From: Simon Davis
Sent: 29 January 2025 13:22
To: Helen Murch [REDACTED]
Cc: Luke Vallins [REDACTED] Peter Cleveland
[REDACTED]
Subject: RE: Planning Consultation on: P/114/24/RES

Simon Davis MRTPI
Principal Planning Officer, Directorate of Growth

Project Land West of Pagham Road
Drawing House Type 2x1M Elevations

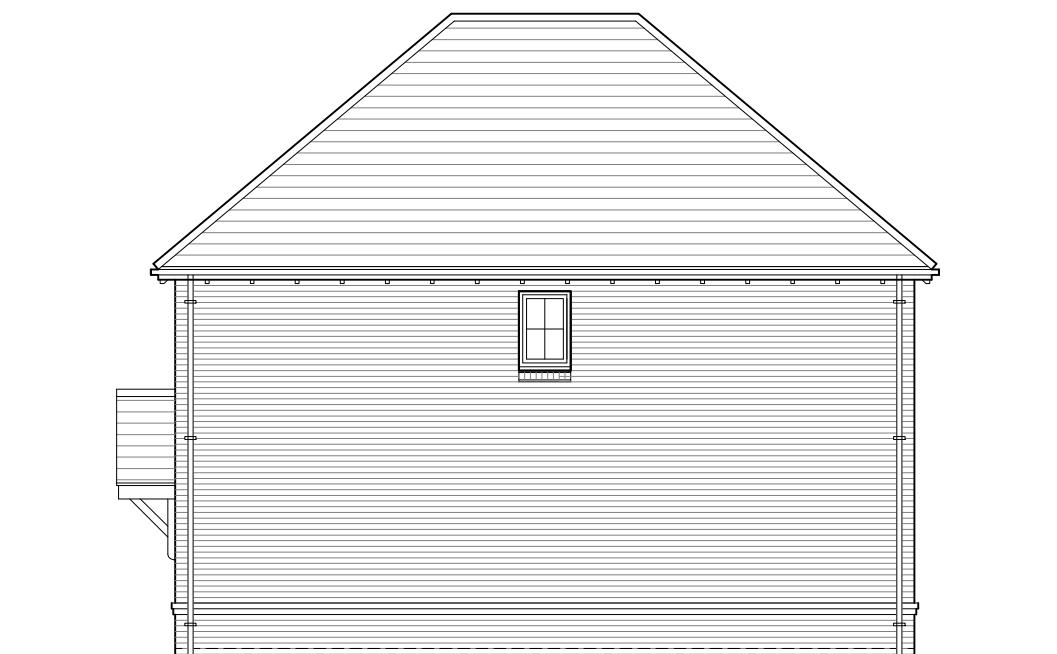
- Southern elevation of plots 36/37 (FF bed, bath, kitchen windows) to rear of 22 Mill View Close is only 13.8m (ADG requires 16/21m – nb the ADG does not specify a front-to-rear specific distance).
- Flank of 21 (FF Landing/bath window) to rear of 23 Mill Close is 12.8m (14.5m)
- Front of plots 33/34 (FF bed, bath, kitchen windows) to the rear of 7 Old Barn Close is 15.7m or 12.6m to its conservatory (need 16-21m).
- Rear of plots 14/15 (2 x FF bed windows) to rear of 8 Mill View Close is 16-17.2m (14.5m to edge of conservatory) (need 21m).

Having visited the site, I observed a high hedge protecting the amenities of 22 and 23 Mill View Close and I note this is being retained. On this basis, I consider their amenities to be protected. However, I retain concerns (which my Team Leader agrees with) concerning the impact on 7 Old Barn Close and 8 Mill View Close which both have conservatories and do not have the benefit of hedge protection (no 7 does have some but there is gap where the conservatory is). I acknowledge that it is proposed to fill in any gaps, but this may take time to grow, and, in the meantime, these two park homes will be subjected to overlooking at close quarters. You will note that we raised these same issues at the pre-app stage. I would not feel comfortable approving a layout which conflicts with the ADG in respect of the relationship to these two existing homes.
